Re: Busconnects Galway: Dublin Road Development, Compulsory Purchase Order No BCGDR-CPO-001-2025
Dublin Road, County Galway

RE: FURTHER SUBMISSION ON BEHALF OF THE CONNACHT HOTEL AND HOSPITALITY GROUP, DUBLIN ROAD, GALWAY, H91 K5DD TO AN COIMISIÚN PLEANÁLA REGARDING THE BUSCONNECTS GALWAY: DUBLIN ROAD DEVELOPMENT COMPULSORY PURCHASE ORDER (REF. BCGDR-CPO-001-2025)

AN COIMISIÚN PLEANÁLA REF. NOS. 321776 AND 321882

Response to Galway City Council's Submission to An Coimisiún Pleanála

BUSCONNECTS GALWAY: DUBLIN ROAD			
LANDS TO BE COMPULSORILY ACQUIRED			A1
DEPOSIT MAP			
SHEET 02 OF 06			
Designed: GW	File Name: BCGDR-CPO-PDV_SI-XX-DR-TX-00002	Drawing No. BCGDR-DM-02	Rev: C01
Drawn: GW	Scale at A1: 1:1000		
Approved: JN	Date: JUNE 2024		
Reviewed: JMcM

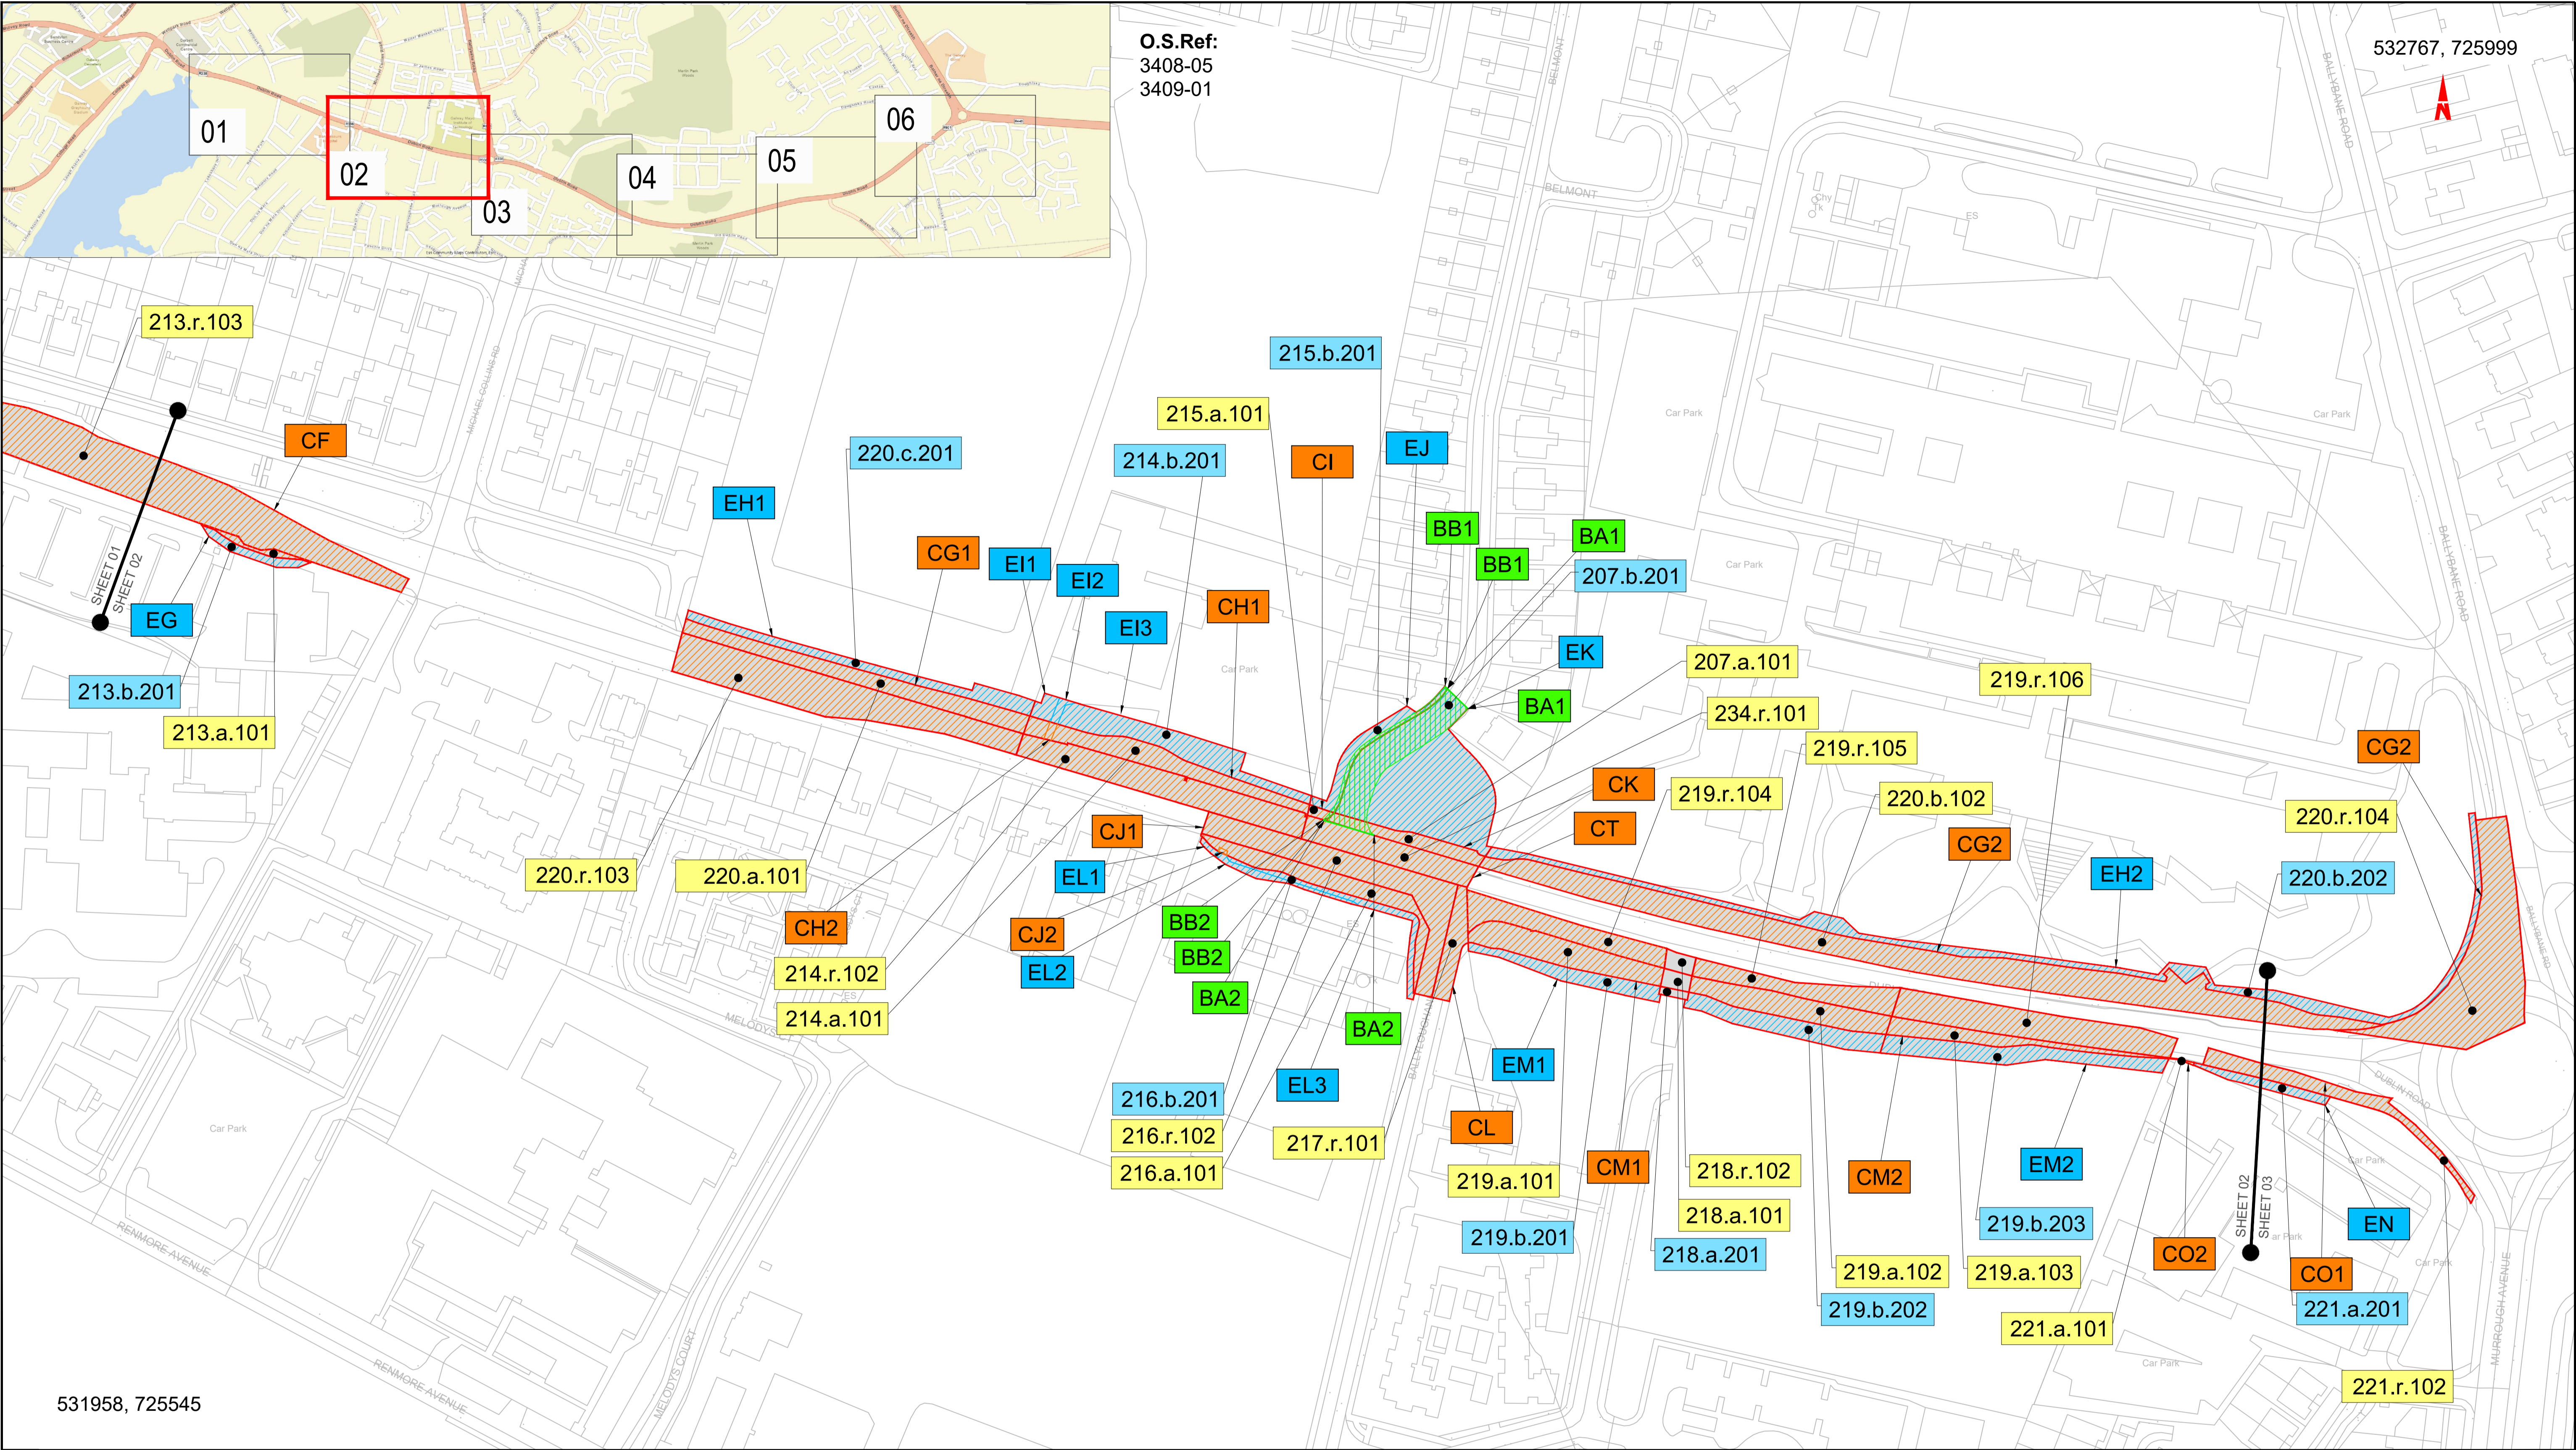
A review of the General Arrangement Drawing (Volume 3, Sheet 02 of 13) and the relevant Deposit Map extracts (Plots 209.a101–103 and 209.c.201–204) highlights a number of outstanding concerns:

- The CPO boundary extends into the landscaped buffer and green verge directly fronting the hotel car park, with no clear indication of how this boundary will be physically separated from marked parking bays.
- The permanent land take appears to encroach upon areas essential to circulation, vehicle manoeuvrability, and guest drop-off, particularly in proximity to the main access point from Dublin Road.

- The temporary land take, as delineated in plots 209.c.201–204, spans nearly the full extent of the hotel's frontage. This raises a significant risk of disruption during the construction phase, particularly in the absence of any detailed phasing, traffic management, or mitigation plan.

Accordingly, we respectfully request that the Board seek further clarification from the applicant, supported by appropriate technical documentation, to confirm:

- That there will be no loss or restriction to marked car parking spaces or key circulation routes at any stage of the works; and
- That a comprehensive phasing strategy, including clear communication protocols and operational safeguards, will be put in place to ensure full functionality of the hotel site throughout the construction period.
